From: Contact Centre (CRM) <contact@ribblevalley.gov.uk>
Sent: 11 July 2024 14:51
To: Planning
Subject: Planning Application Comments - 3/2024/0029 FS-Case-630032404

Planning Application Reference No.: 3/2024/0029

Address of Development: 5 The Dene, Hurst Green

Drwg No
1424-PL06E

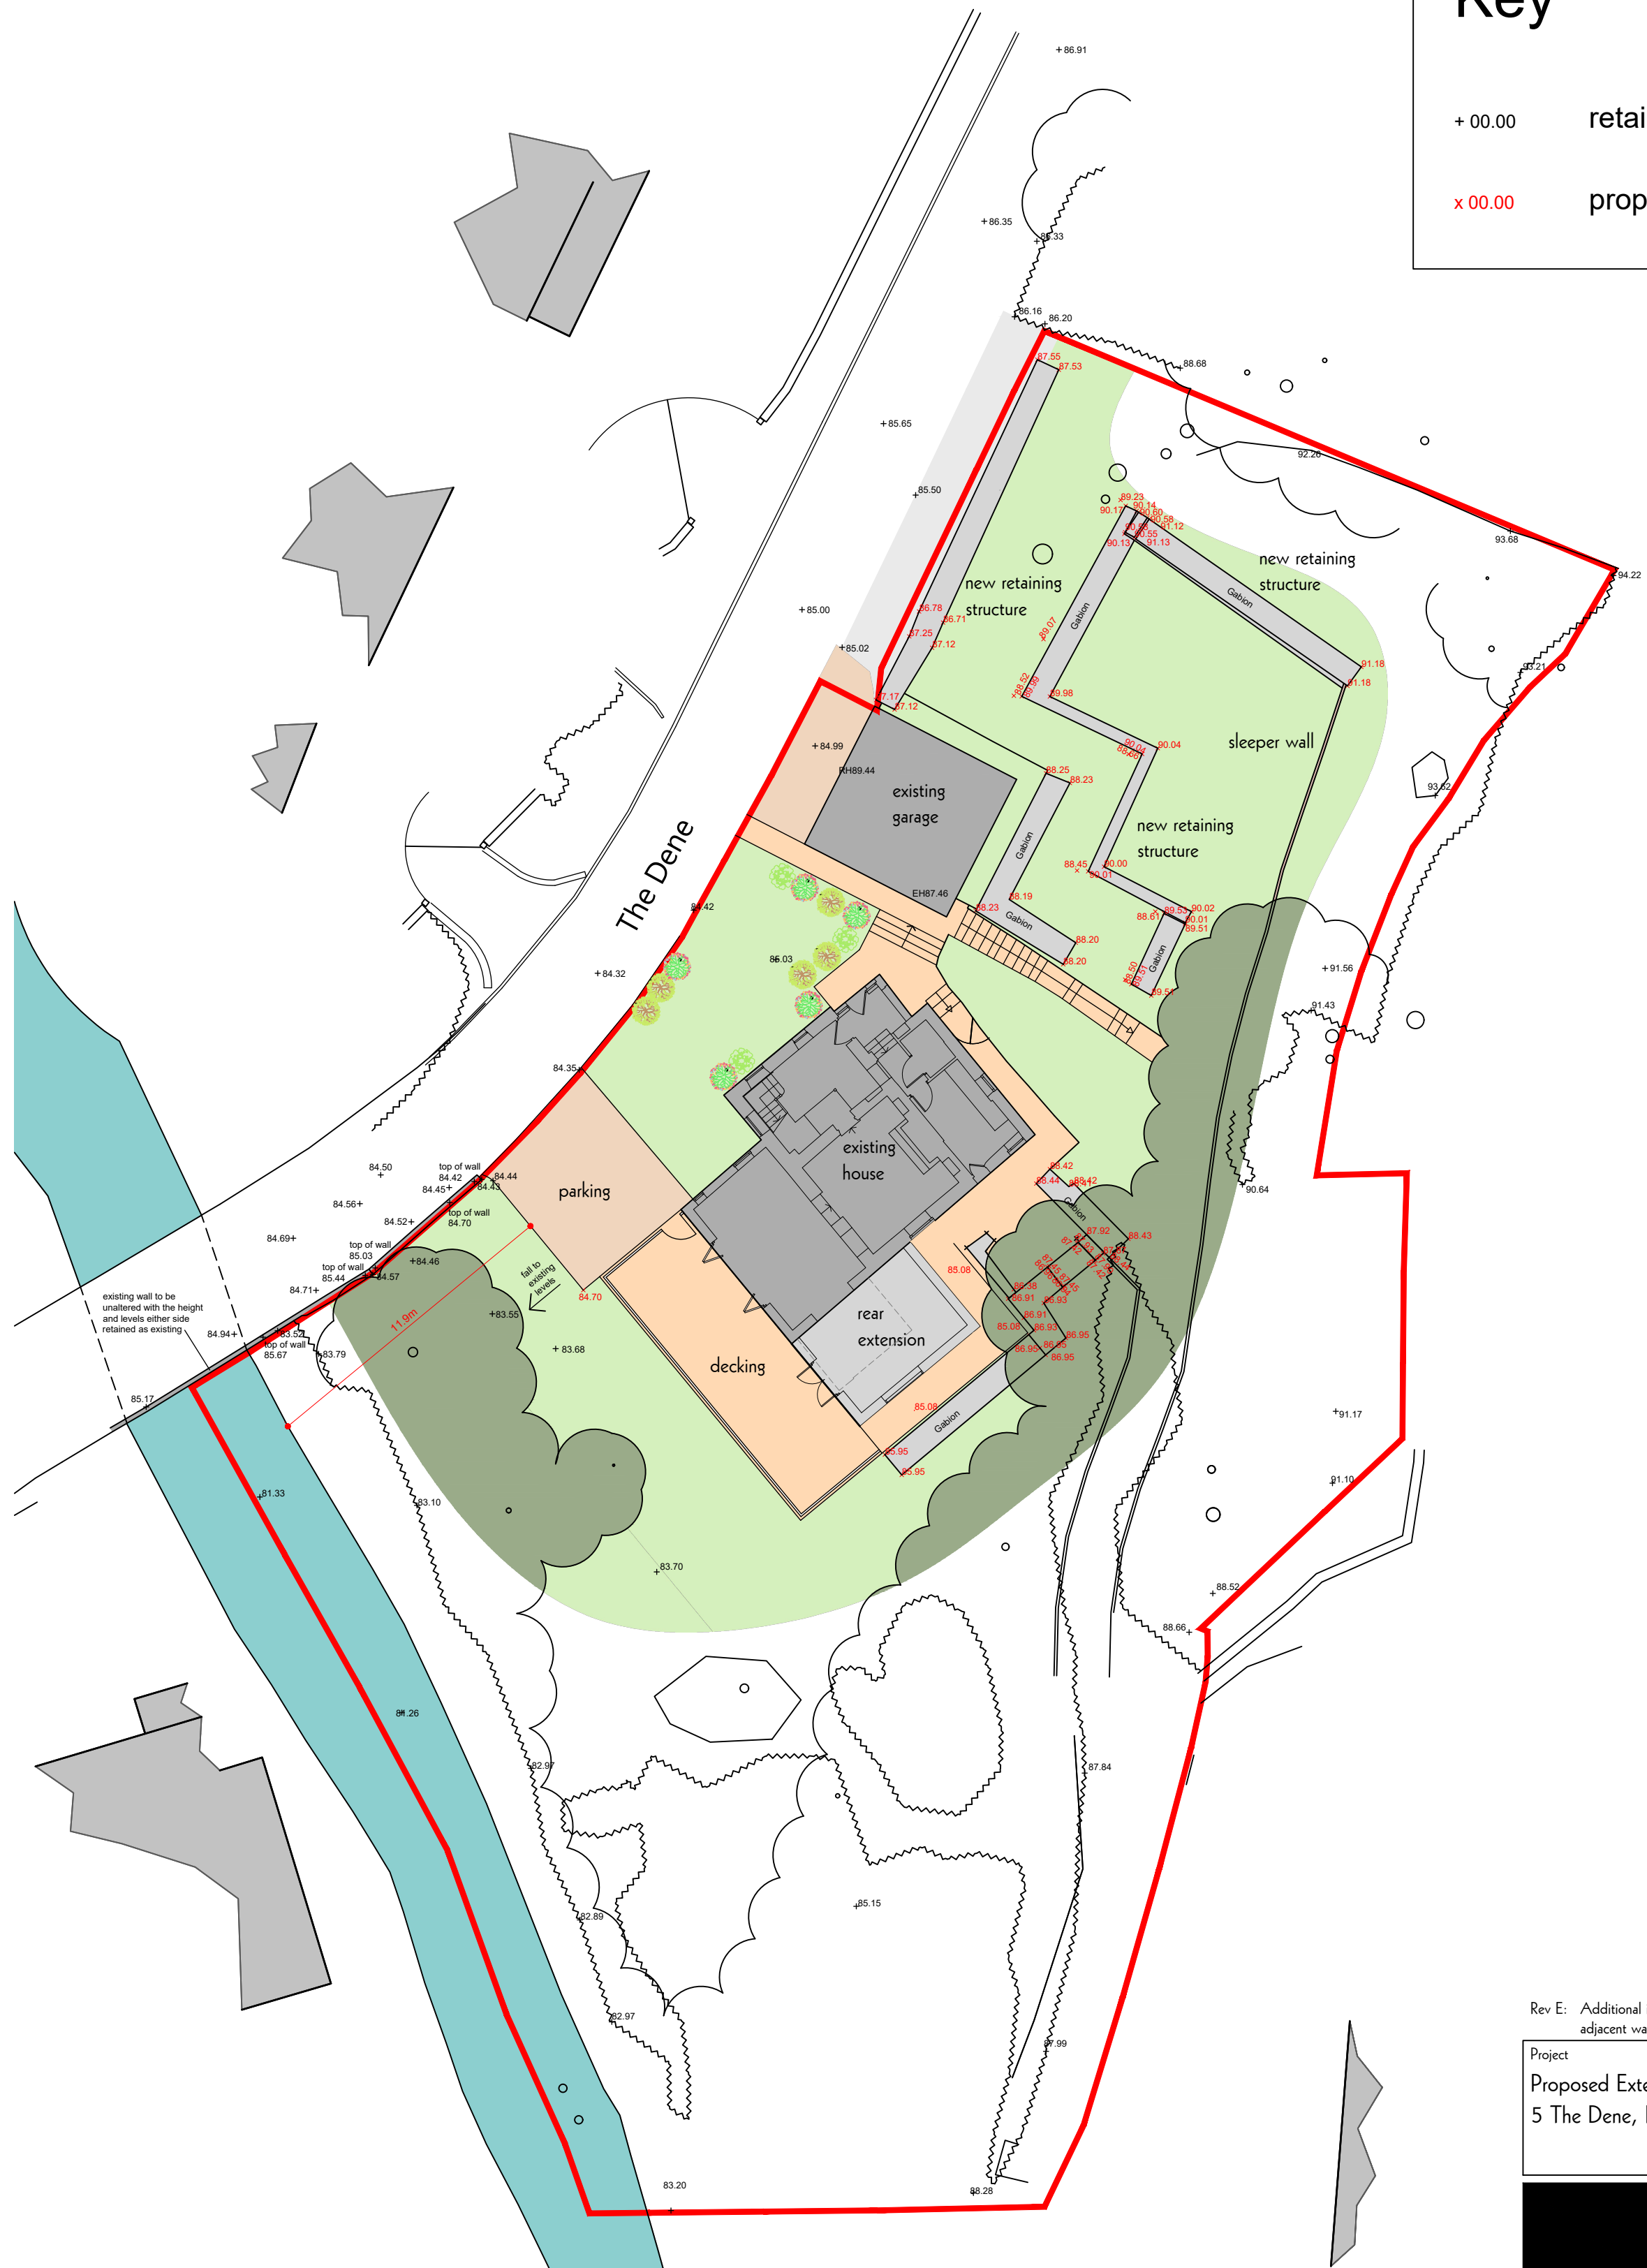
Comments: After overlaying the amended Existing & Proposed site layouts, I can see no reflection of the alteration to land levels for this development. I know that there has been in excess of 100 Tons of contaminated spoil from other developments and from the digging out of the work already undertaken at the property. I must also bring to your attention the following additional issues.
